**Consultation Response from KC,
Lead Local Flood Authority**

**2025/93435 Land off, Blackmoorfoot Road and Felks Stile Road, Crosland Moor, Huddersfield,
HD4 7AD**

Discharge of details reserved by conditions 17 (structures in HW), 18 (drainage strategy) and 20 (foul water drainage) on BOTH RESIDENTIAL PARCEL OF previous permission 2024/92614 for variation and removal of conditions 4 (access works), 8 (Blackmoorfoot Road improvements), 10 (junction details), 16 (retaining wall design), 17 (highway structure design), 18 (surface water drainage strategy), 37 (external lighting strategy), 39 (crime mitigation measures) on previous outline permission 2020/92546 (with details of points of access only) for the development of up to 770 residential dwellings (Use Class C3), including up to 70 care apartments (Use Classes C2/C3) with doctors surgery of up to 350 sqm (Use Class D1); up to 500 sqm of Use Class A1/A2/A3/A4/A5/D1 floorspace (dual use), vehicular and pedestrian access points off Blackmoorfoot Road and Felks Stile Road and associated works

Condition 18 – Surface Water

Project: **Blackmoorfoot, Huddersfield**  
 Title: **S104 BMF - Impermeable Area Plan**

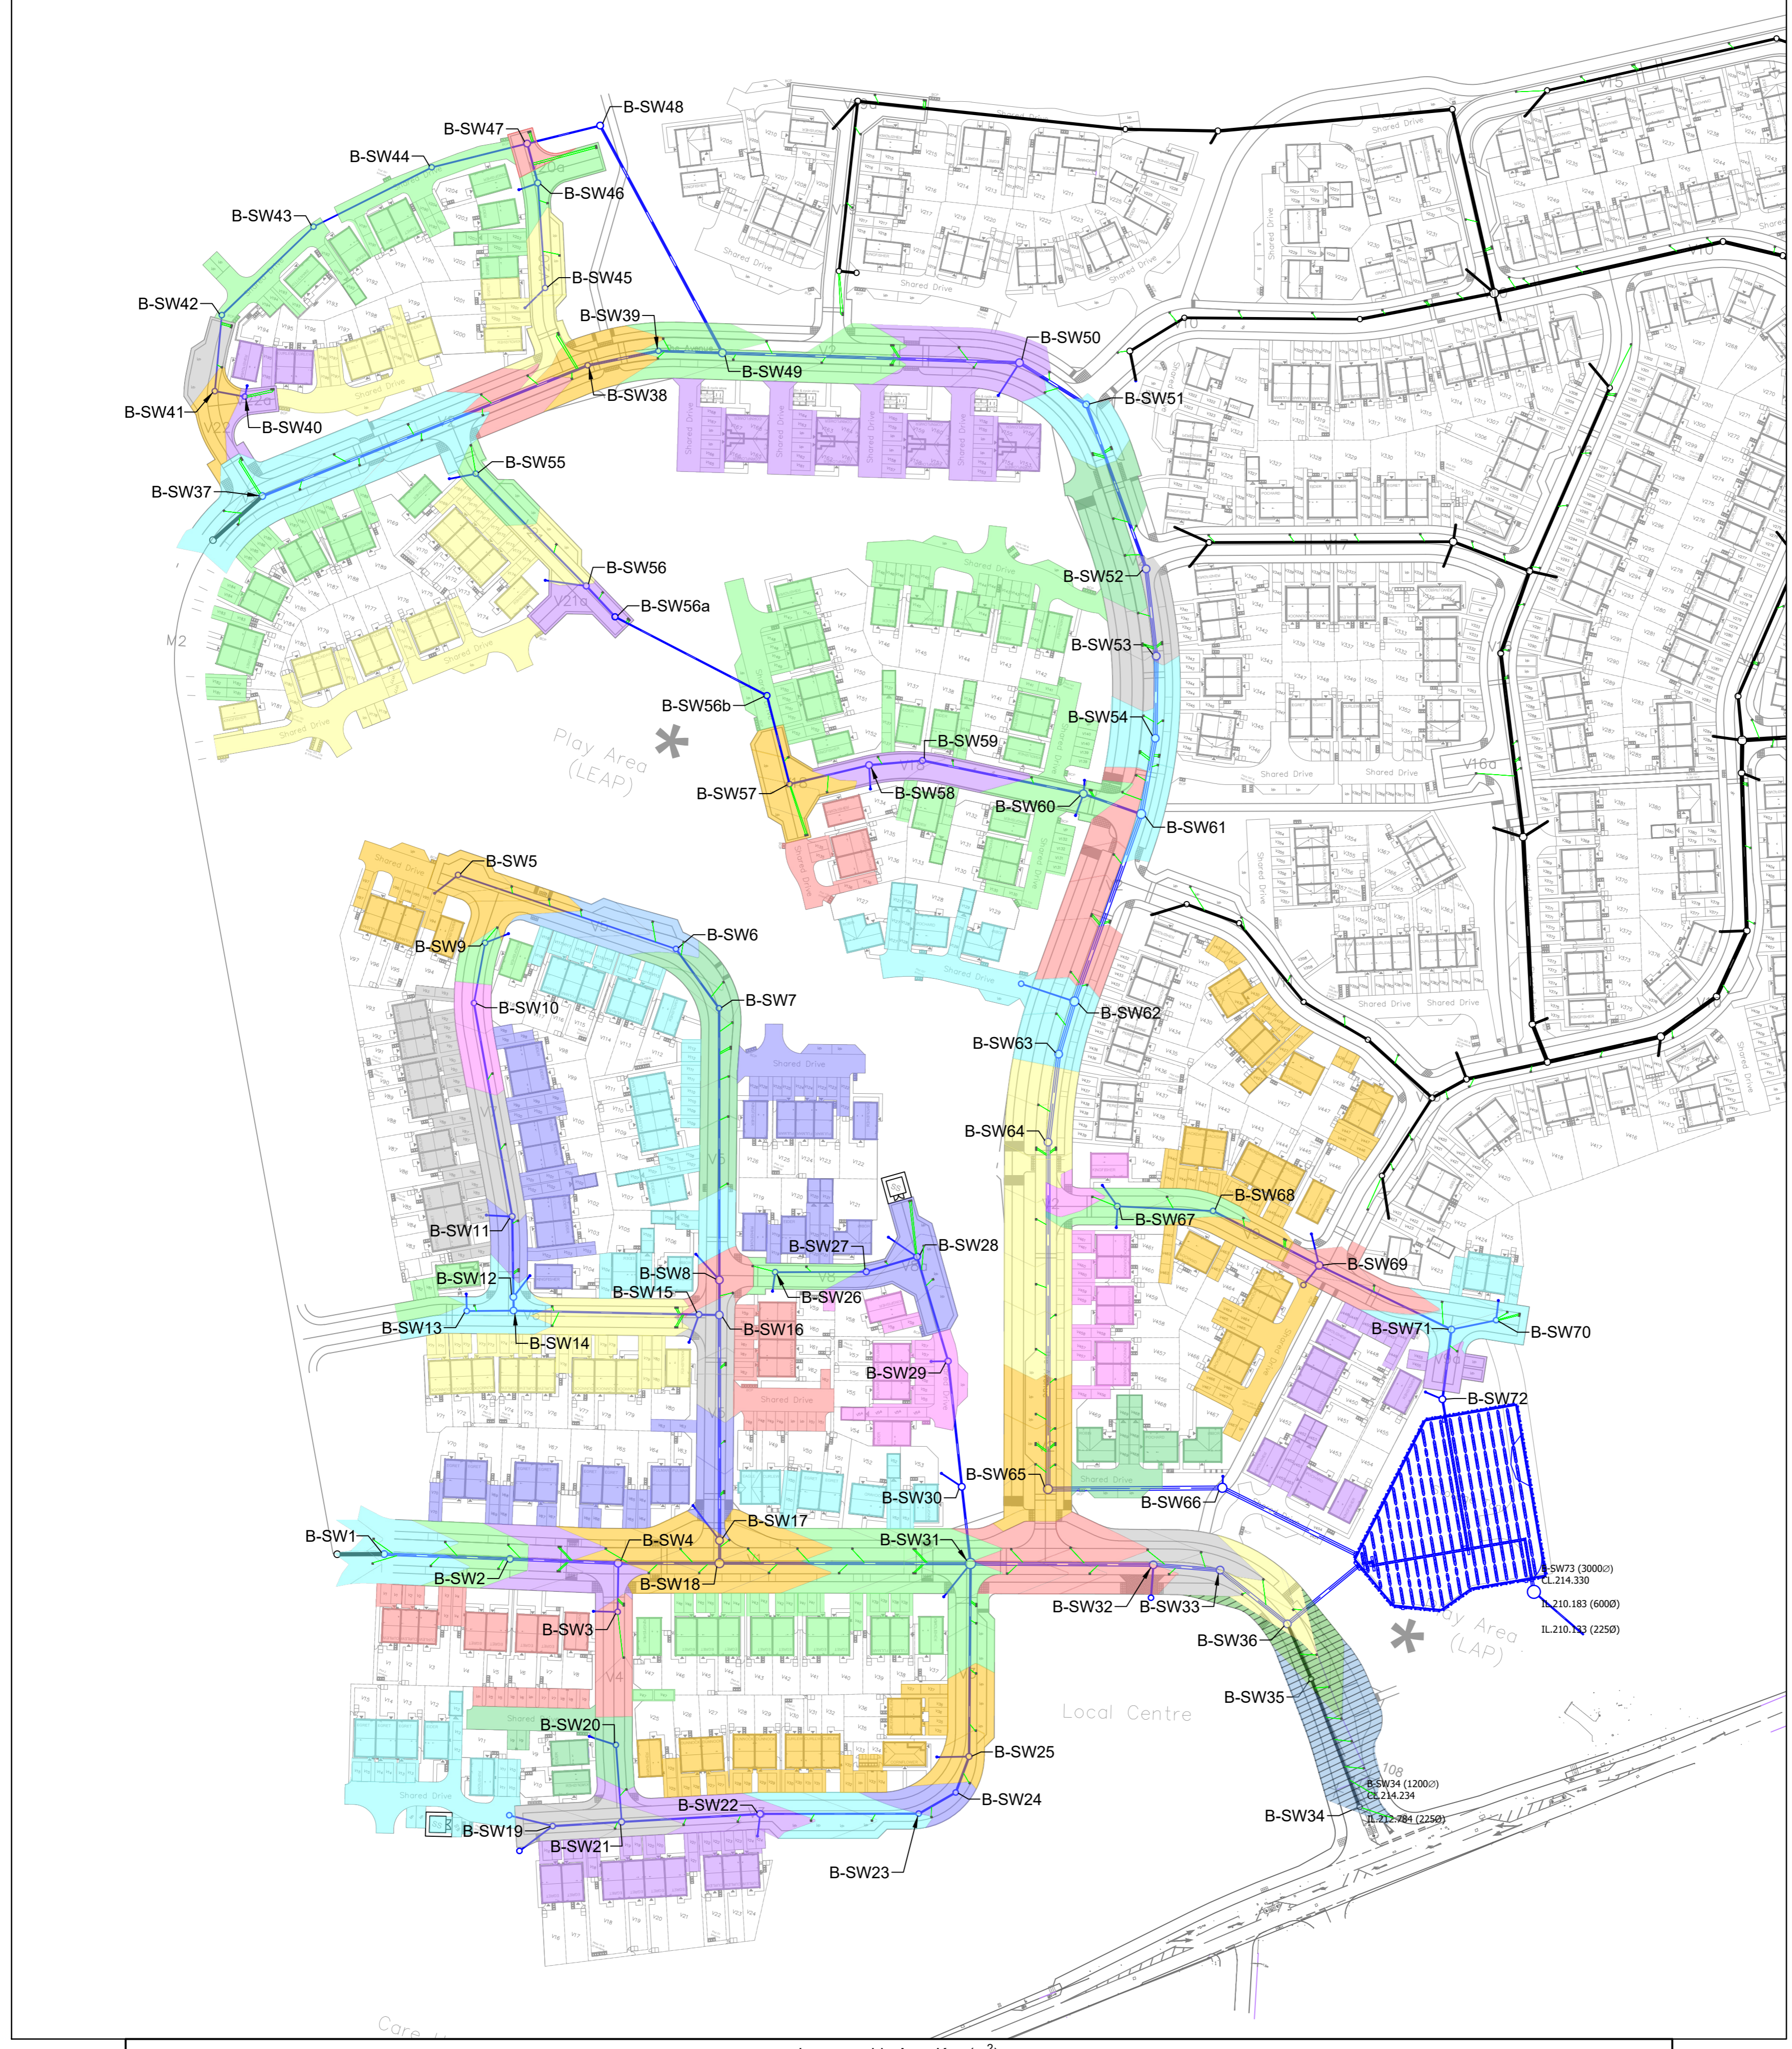
Coloured hard standing drawings continue to be inaccurate. Road gullies clearly showing connecting to different legs of sewer occupy the same colour. These drawings need a wholesale review.

Once this is done and is accurate, hydraulic calculations should minim this map.
